From: Martyn White
Sent: 26 April 2019 13:26
To: Planning.Responses
Cc: Zac Denton
Subject: LU/76/19/PL

LU/76/19/PL

The application relates to a replacement shop front in the front elevation of the building. The proposal is for the glazing to be simplified, but the overall impression is that the new shop front appears similar to the existing design.

Proposed Elevation

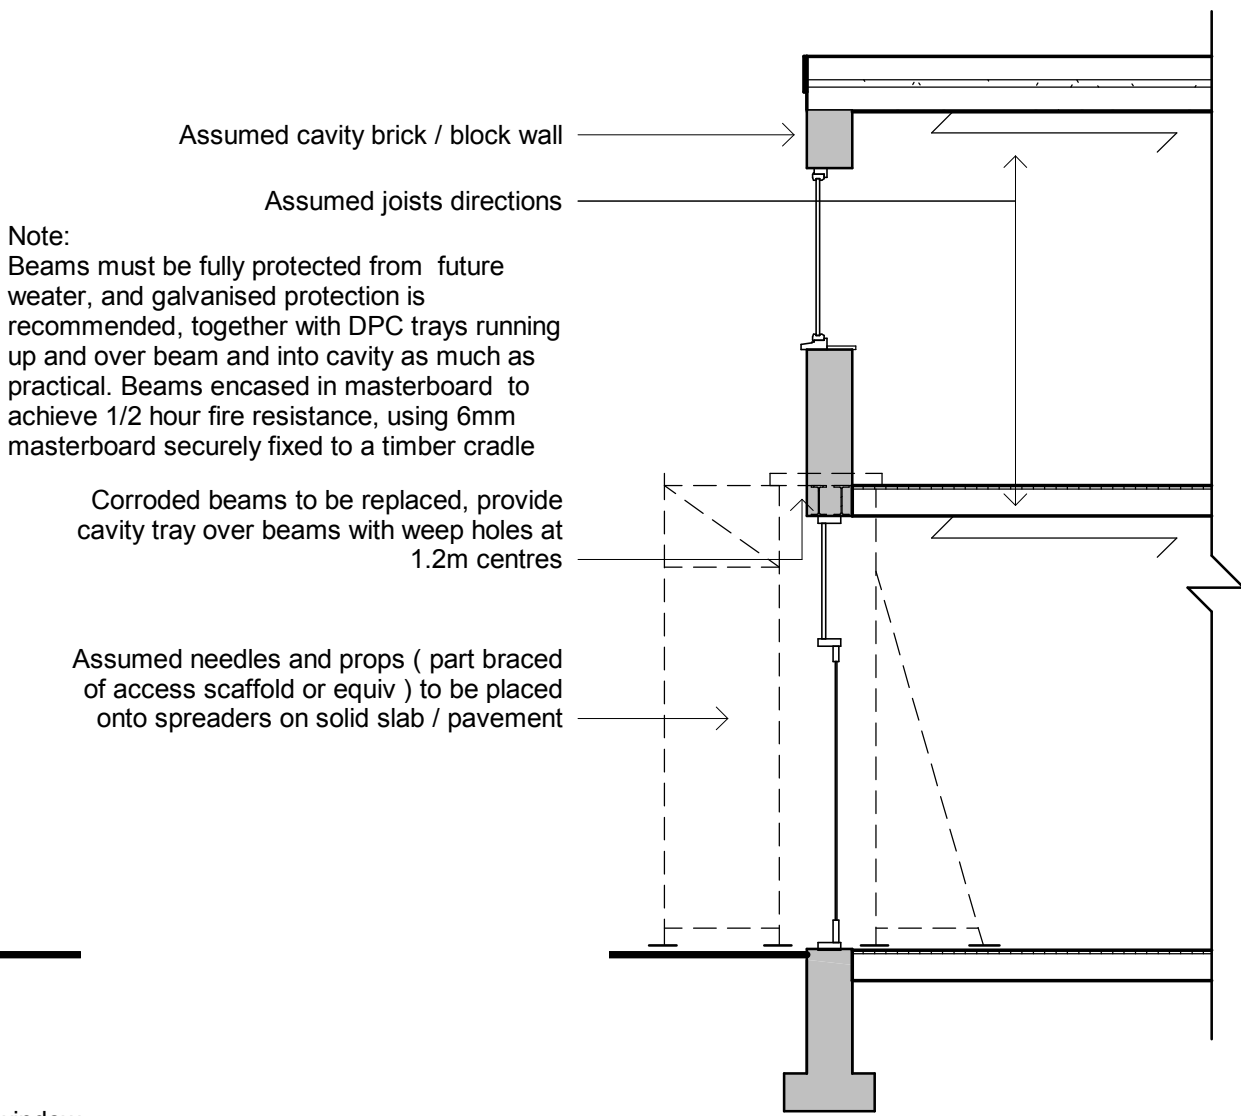
I note that there does not appear to be any information related to the colour of the new shop front, and this could be supplied by way of condition, if you are minded to approve the application.
